**Re: Sage Plaza at 1125 Snow Vista Blvd. SW
Erosion and Sediment Control Plan
Engineer's Stamp Date Missing (M09E012)**

Based upon the information provided in your re-submittal received 6/29/2023, the above-referenced ESC Plan cannot be approved until the following comments are addressed.

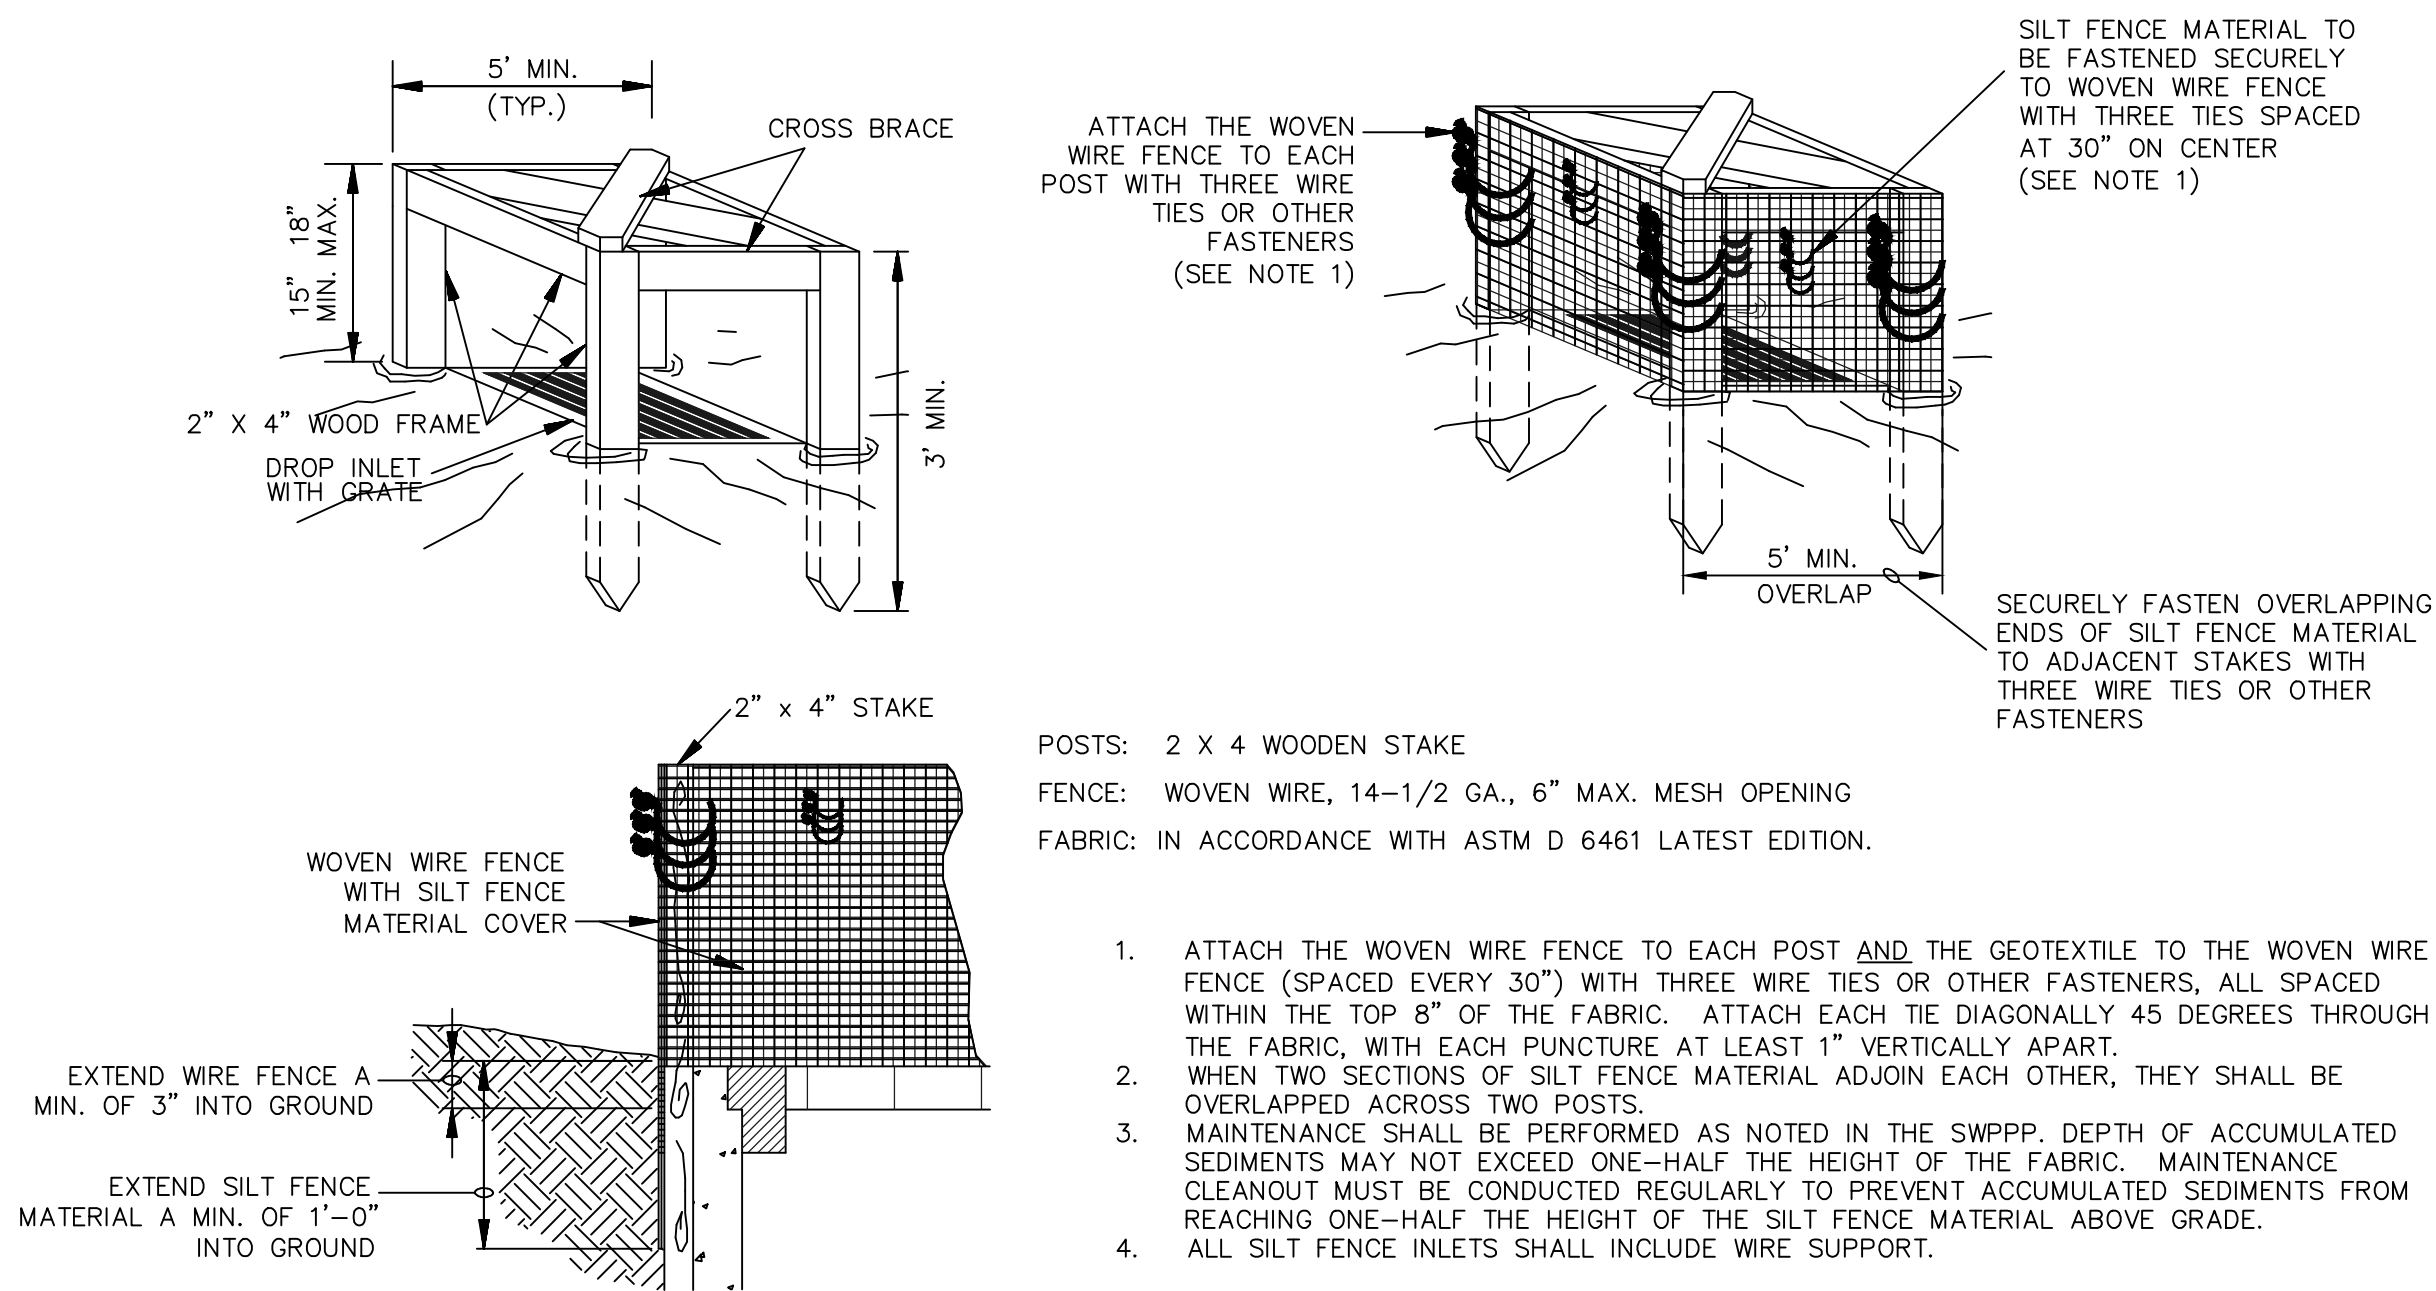
1. The NOI must be signed by a Trustee of Goodman Lawrence RVT.
2. The storm drain that is shown in the west part of the disturbed area hasn't been approved for construction with the subdivision. Please revise the ESC Plan in accordance with the G&D Plan approved by Hydrology for Subdivision Construction. Also, please revise the limits of disturbance to preserve more existing vegetation.
3. Update the engineer's stamp date each time the plan is changed.
